BRADLEY POINT FILING NO. 1-DRY SUBDIVISION SITE DEVELOPMENT PLAN

MARCH 2024

EL PASO COUNTY FILE NO. PPR243

BRADLEY POINT FILING NO. 1
SITE DEVELOPMENT PLAN
JOB NO. 70-077
DATE PREPARED: 05/31/24
DATE REVISED:

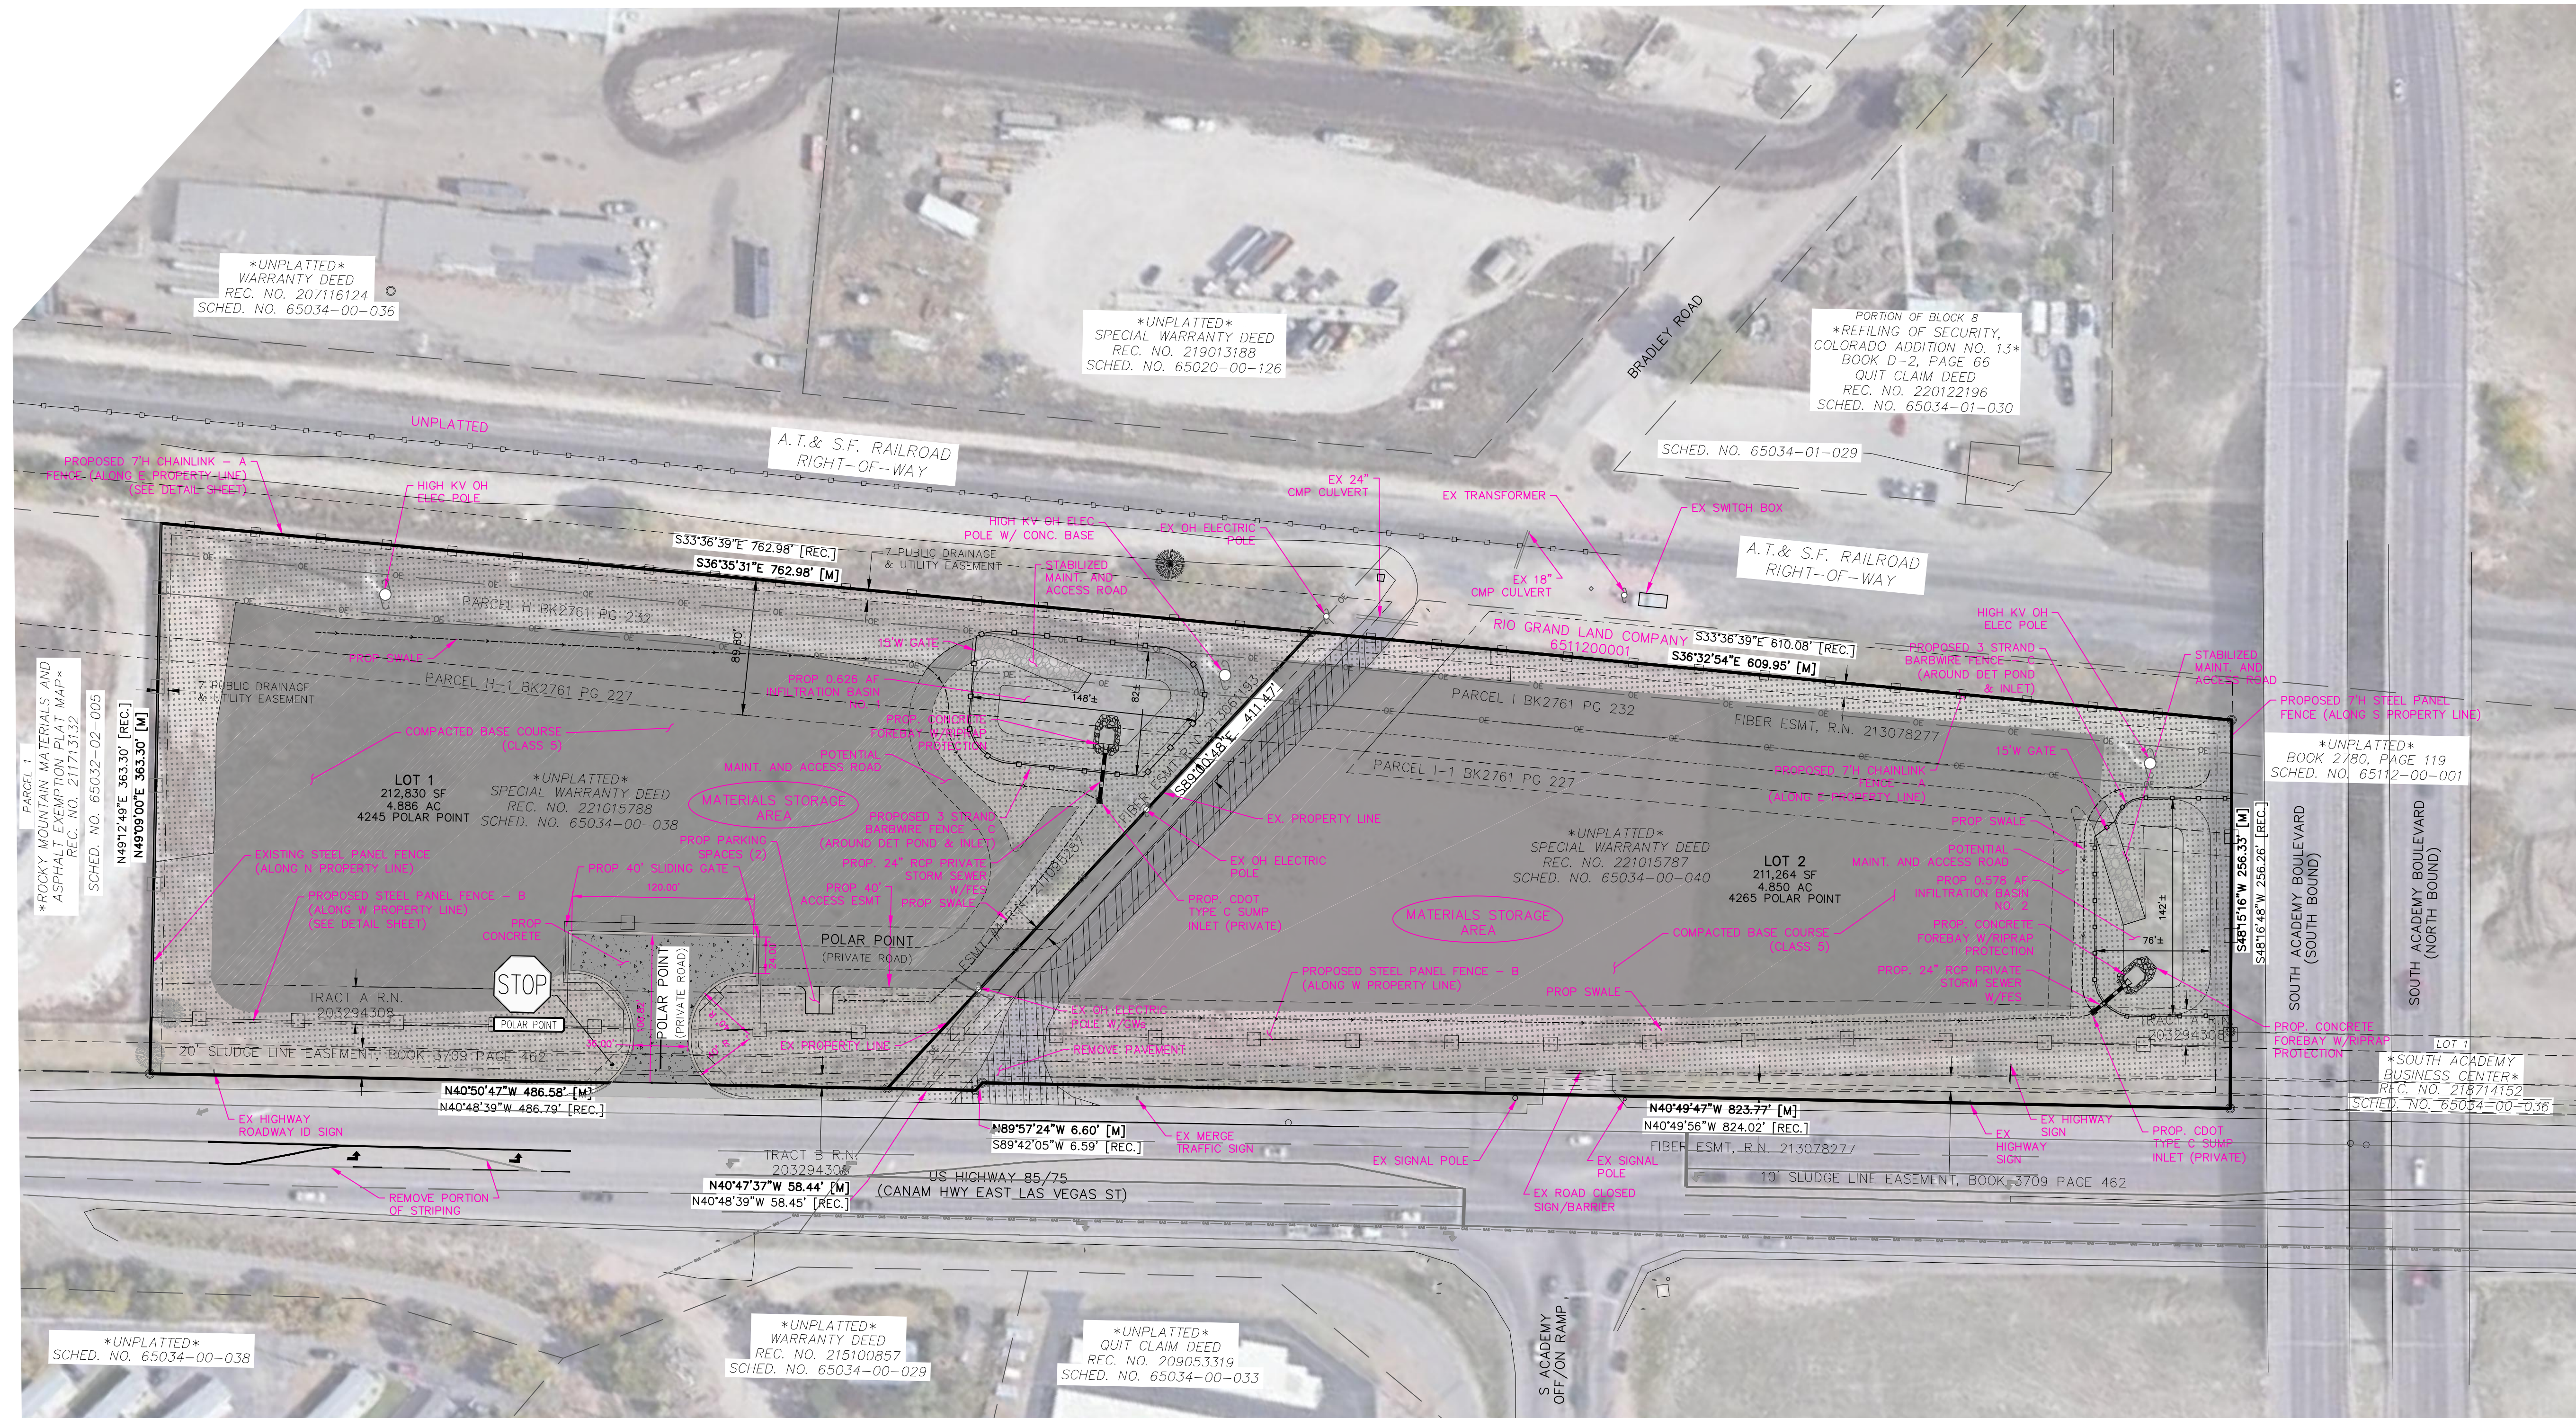
Please depict where
these are located on
the site
